Ribble Valley Borough Council
Housing & Development Control

Application no: **3/2023/0197**

Address: **Keepers Cottage Northcote Road Langho BB6 8BD**

Proposal: **Approval of details reserved by conditions 4 (Landscaping Plan), 10 (Construction Management Plan), 17 (Foul and Surface Water) and 20 (Details of heat pump) of planning permission 3/2022/0637.**

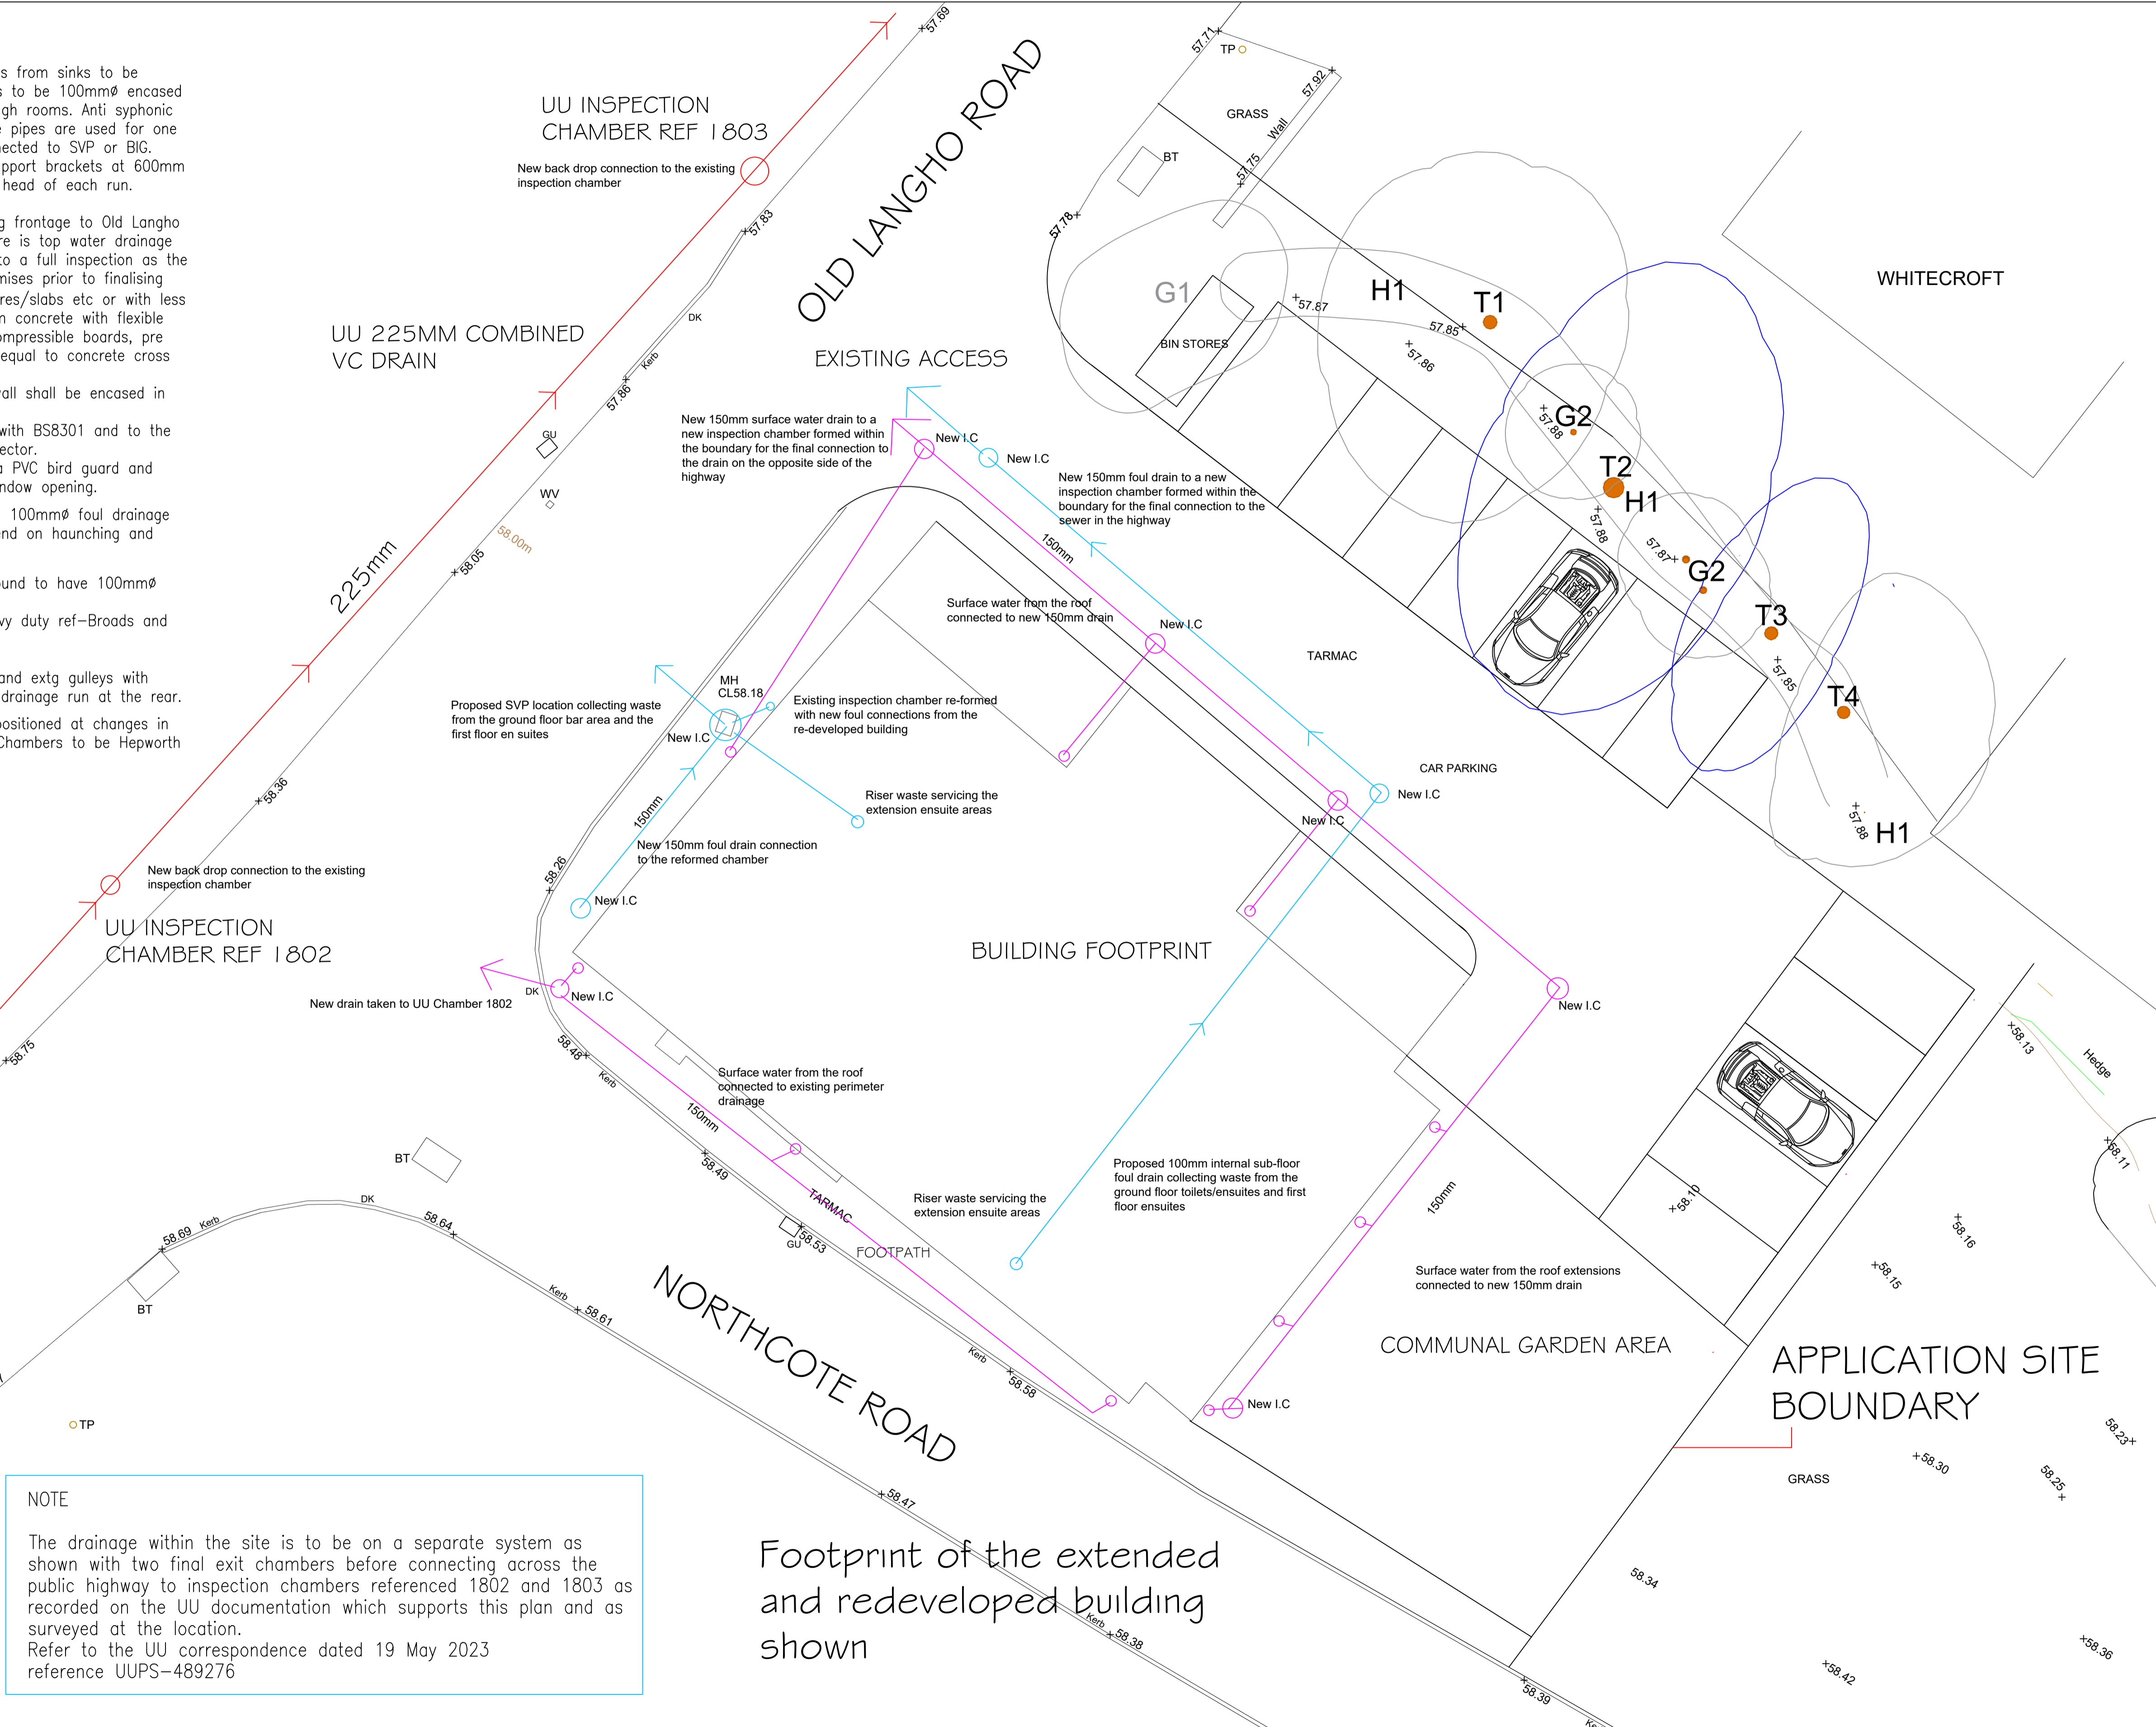
The LHA have reviewed drawing number 5000 Rev A titled "Drainage Strategy Plan" and have no objection to the discharge of condition, with the site not connecting to any highway gullies or drains.
